**SUBJECT: Ellicott Town Center
JPS Responses to CDOT Drainage Review Comments**

This letter is intended to provide a response to the CDOT review comments pertaining to our Final Drainage Report in your letter dated June 20, 2019. These drainage review comments have been addressed as follows:

SHEET:
D1.01

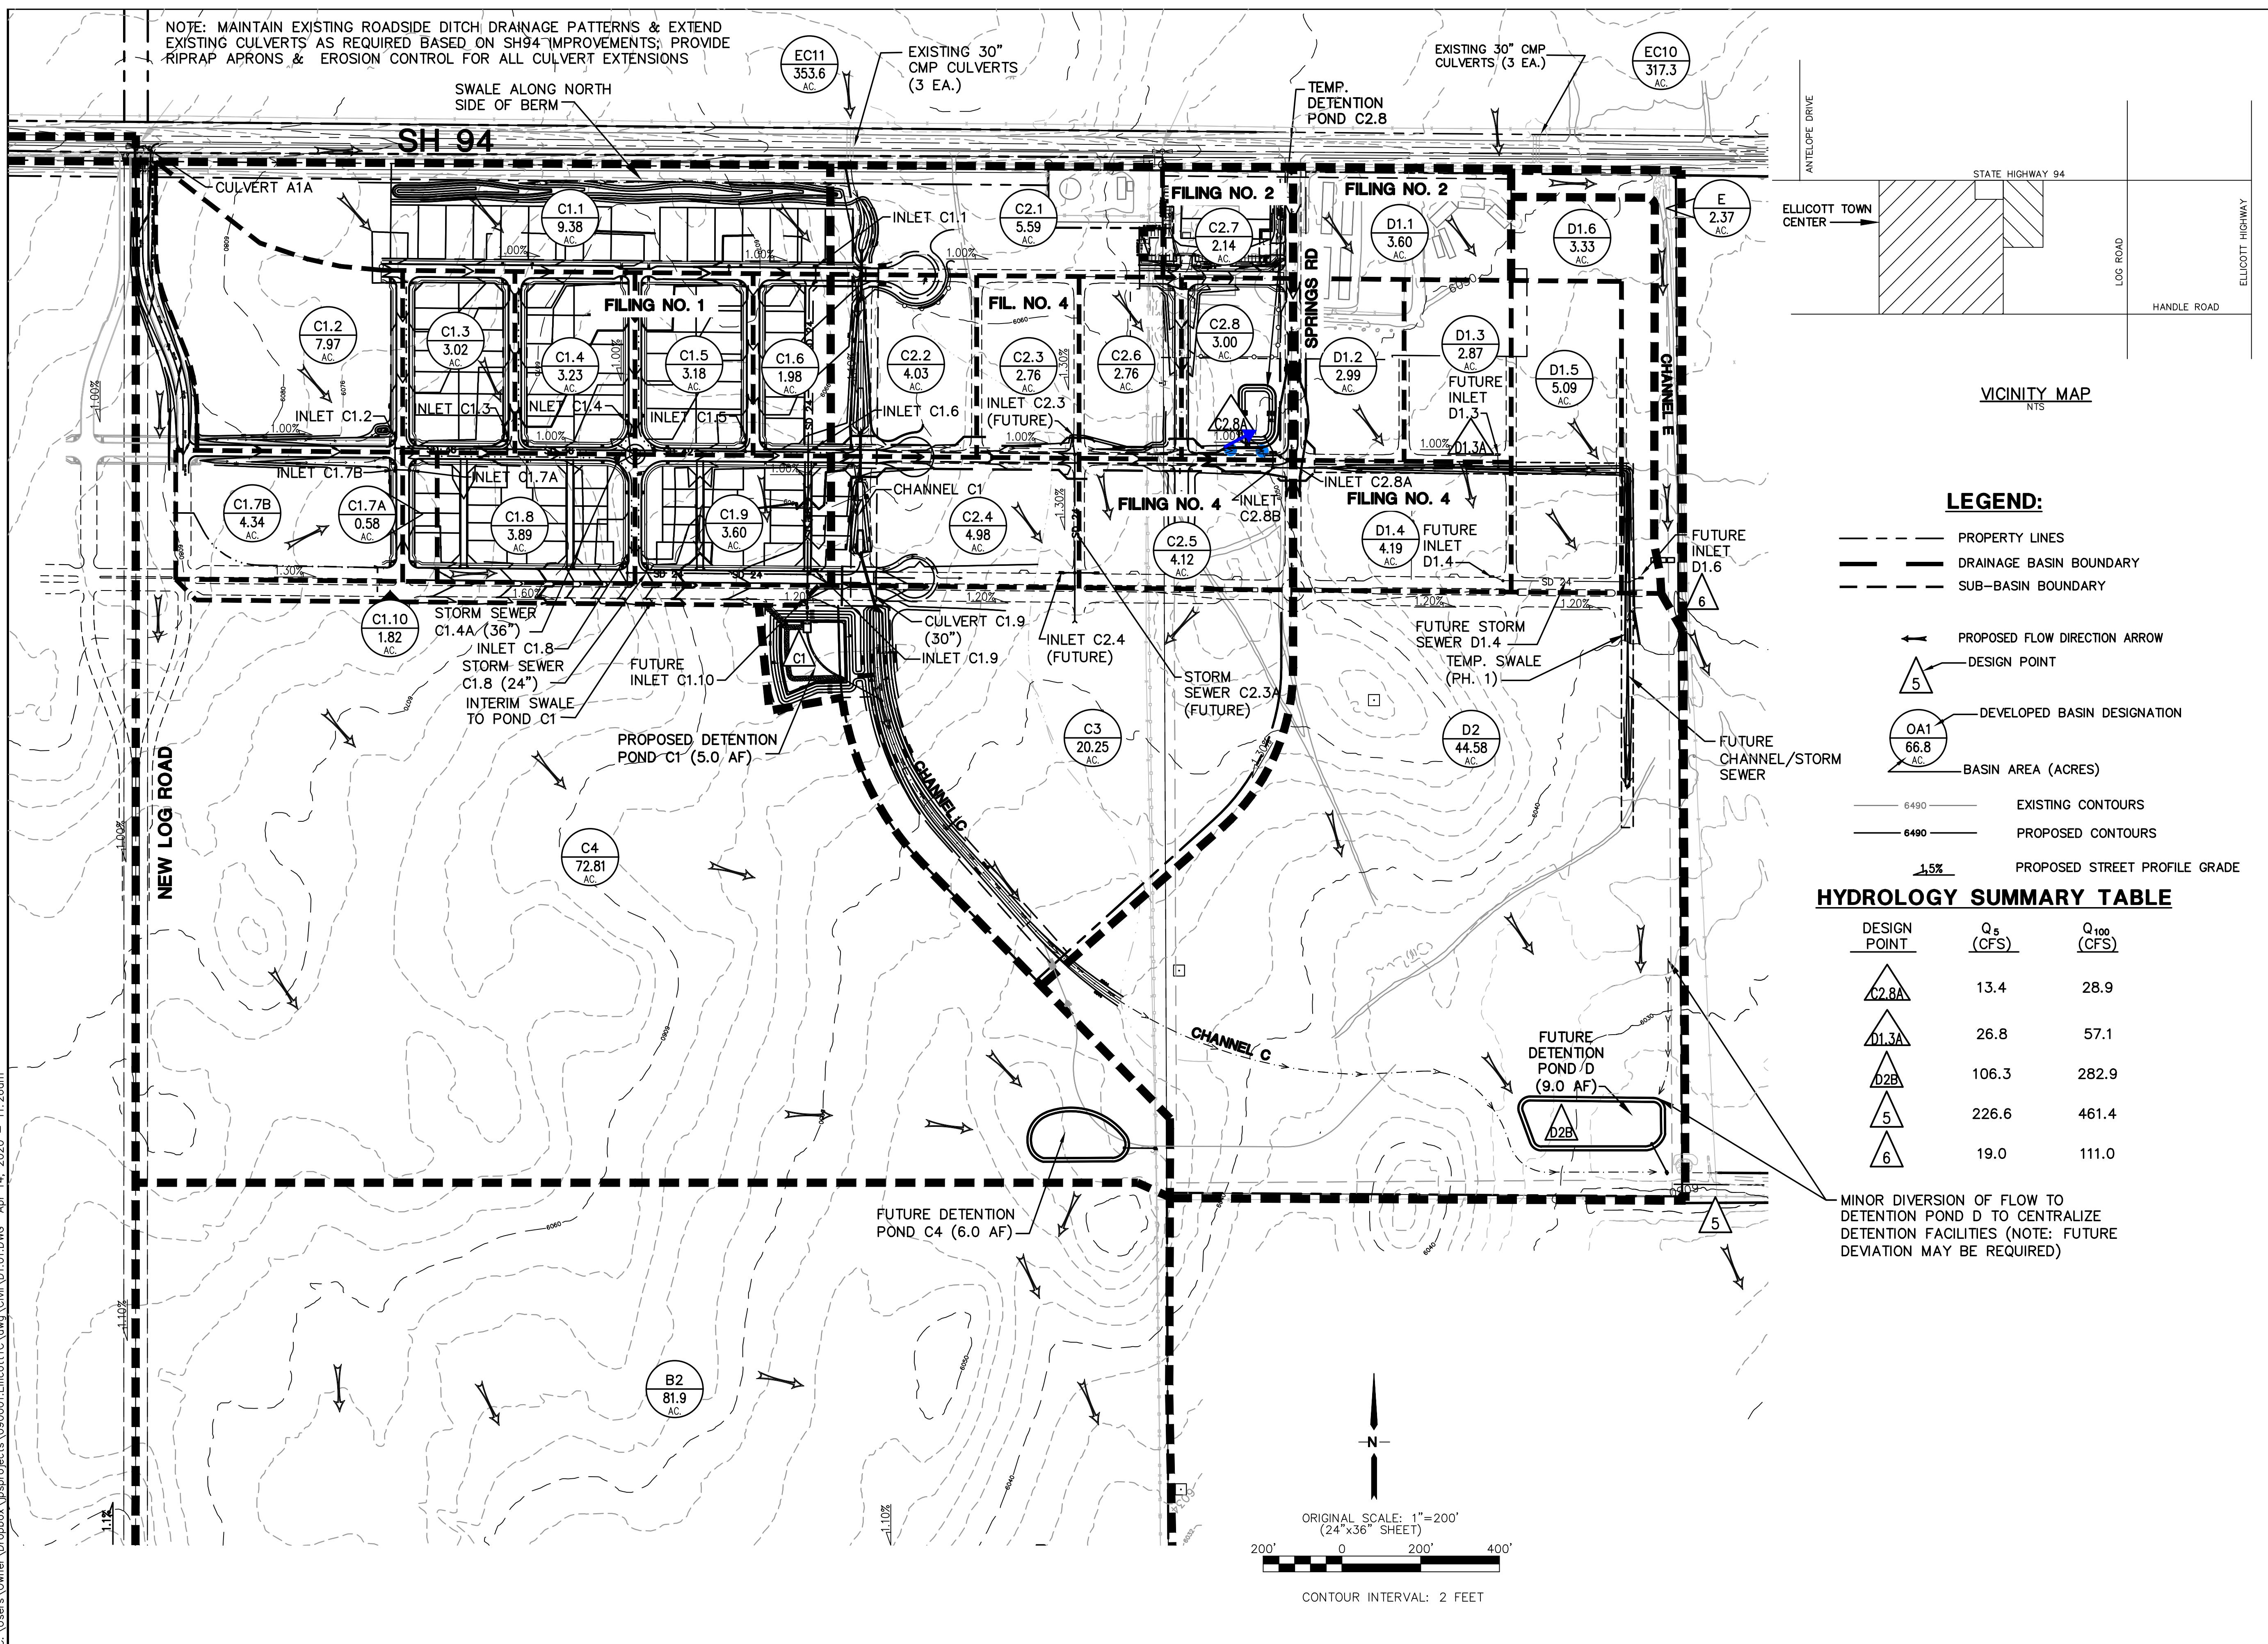
- The proposed berm on the south side of the CDOT ROW is not intended to block any drainage flow. A drainage swale will flow easterly along the north side of the berm, and the existing ditch along the south side of SH94 will continue to flow easterly to the existing culvert crossings. The existing 30" CMP culverts crossing SH94 will be extended as required based on roadway widening for highway access improvements. Details for extension of existing culverts and associated erosion control measures will be included in the Highway Access Improvement Plans.

- Details for any required extension of the easterly existing 30" CMP culverts will also be included in the Highway Access Improvement Plans. The existing drainage channels flowing southeast from the culverts crossing SH94 will be preserved and/or improved as detailed in the subdivision construction drawings.

- Notes regarding maintenance of highway ditch drainage patterns and extension of existing highway culverts have been added to Sh. D1.01 in the updated Final Drainage Report.
